CONSULTEE RESPONSE ON PLANNING APPLICATION 20/00961

Location SOUTH LODGE, FOOTBALL GREEN,
MINSTEAD, LYNDHURST, SO43 7FR

Objection received from Building Design & Conservation Area Officer

PROPOSED FLOOR PLANS

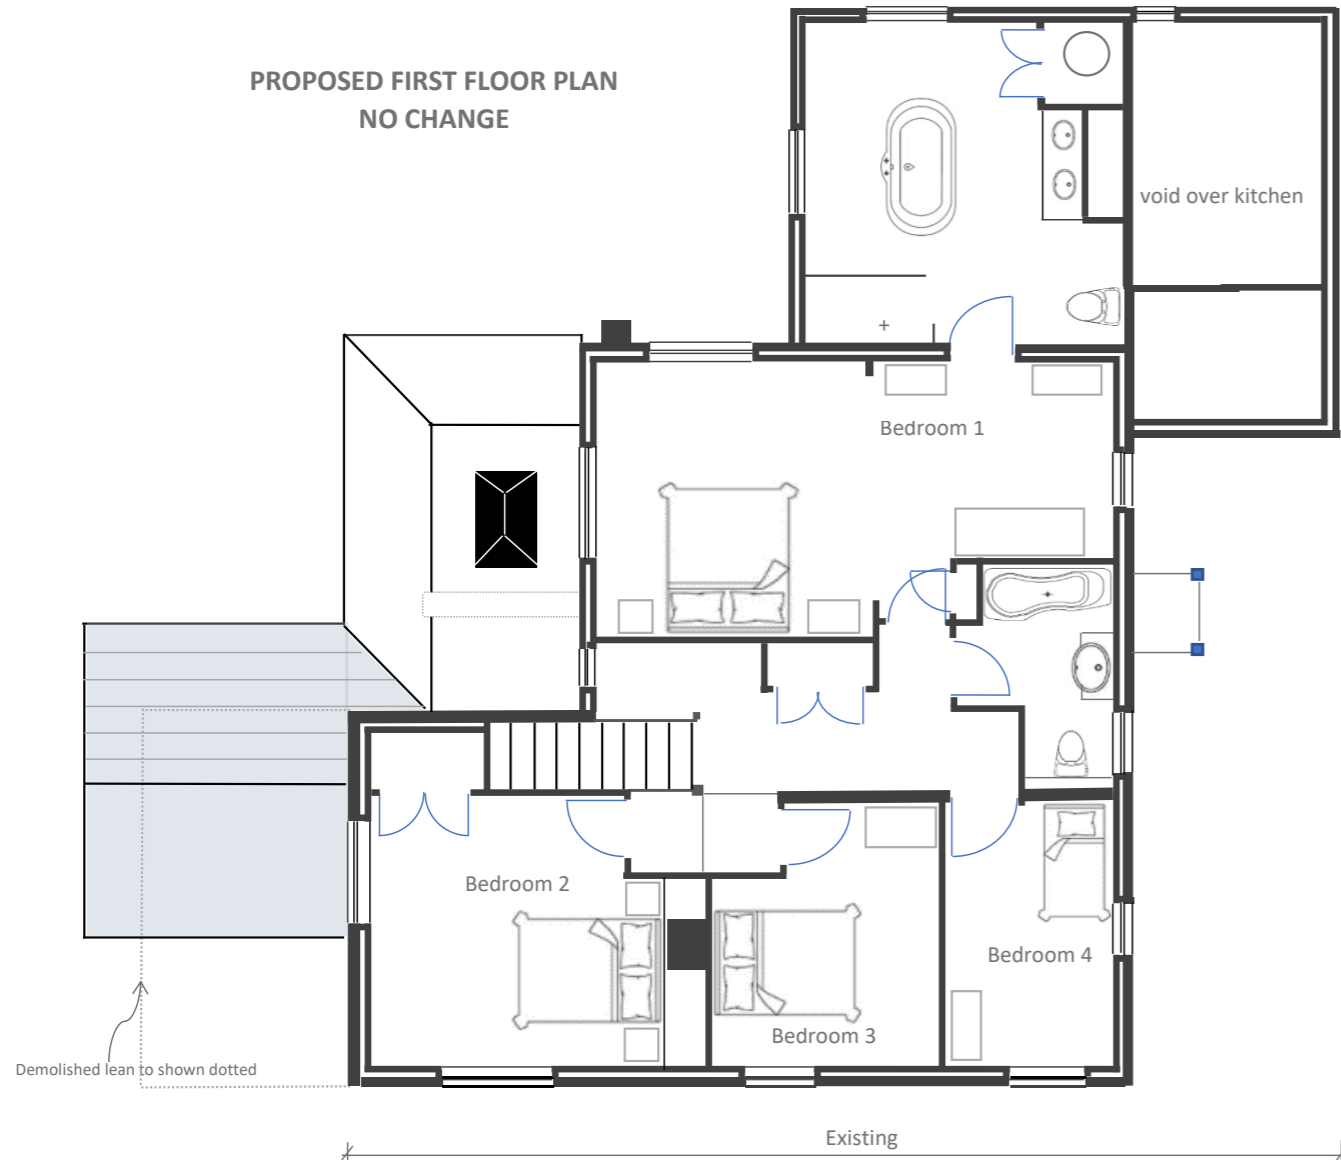
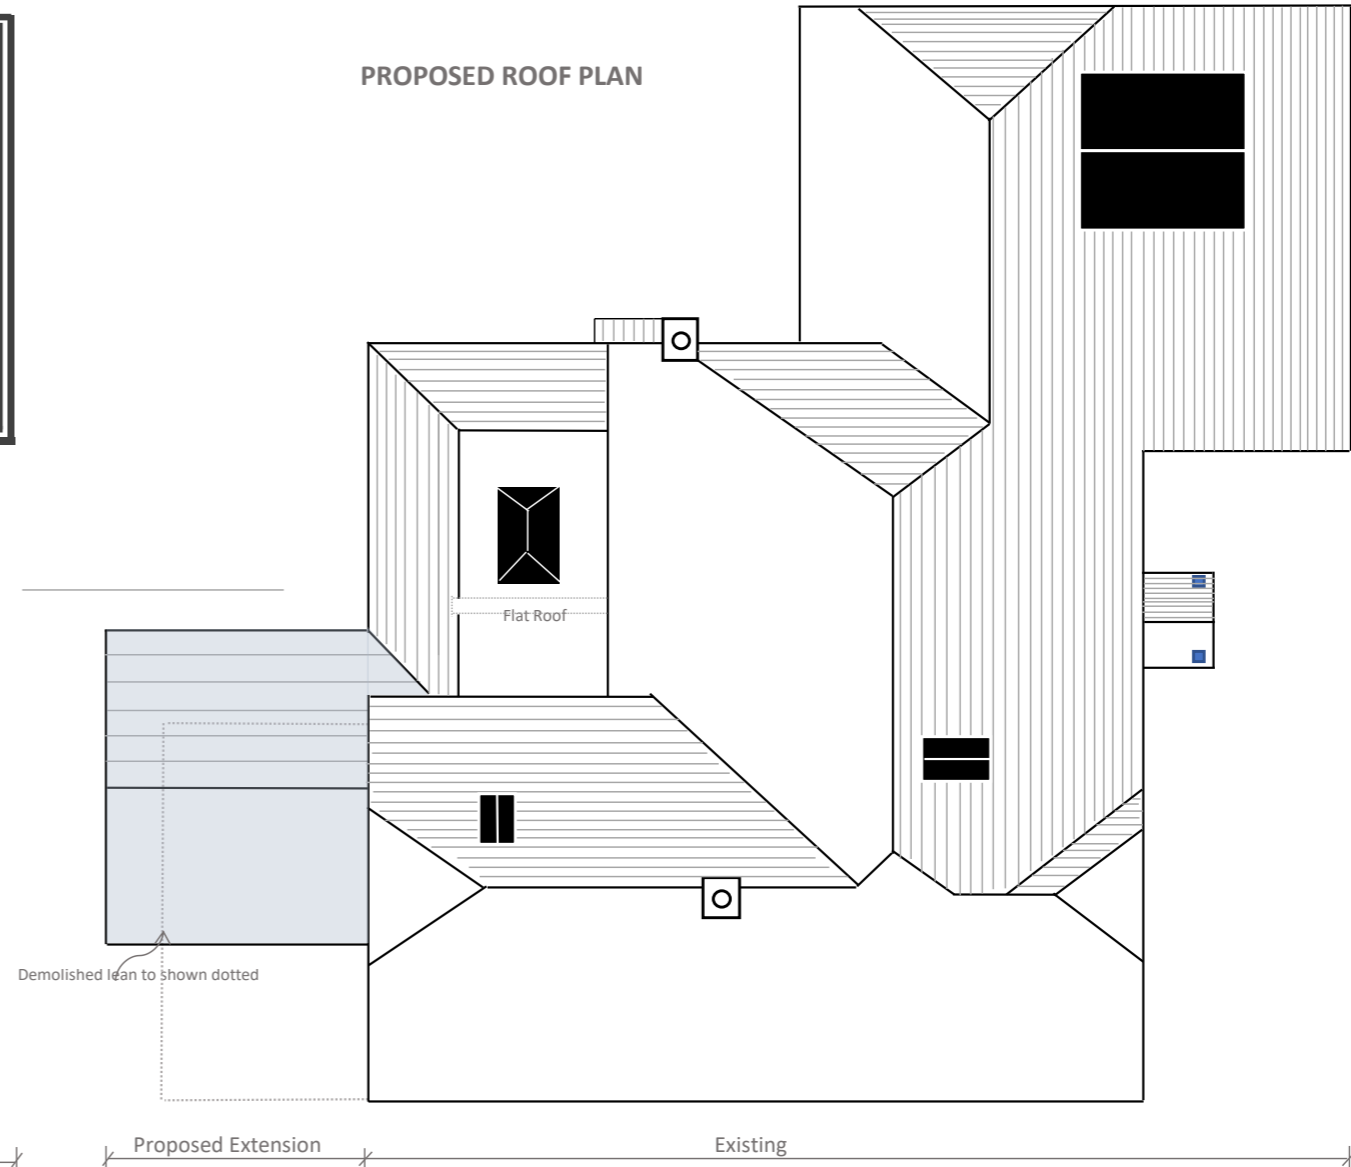
The design of the proposed garden room is very standardised, which does not compliment or fit with the idiosyncratic rural character of this historic cottage. While the shallow roof pitch has been included to avoid obscuring the first-floor window, it sits uncomfortably against the elegantly steep roof pitches used on the rest of the property, making it look squat and out of place. Furthermore this design proposes to dramatically increase the amount of glazing to extend around all three external elevations, which gives the design a suburban character. Therefore it is not considered to conserve or enhance the historic architecture or aesthetic significance of the property or the rural character Conservation Area more widely. Given that this extension will become part of the original principal elevation (south-west elevation) and will be visible from Football Green, it is important the design compliments and respect the rural and historic character of the cottage, which this design does not.

A far more appropriate solution would be to construct the bespoke design proposed in 2016 that carefully complimented the cottage's architectural character, but reposition the footprint of extension to be further north-east (by about 2.4m as suggested in this application) to avoid obscuring the first-floor window.
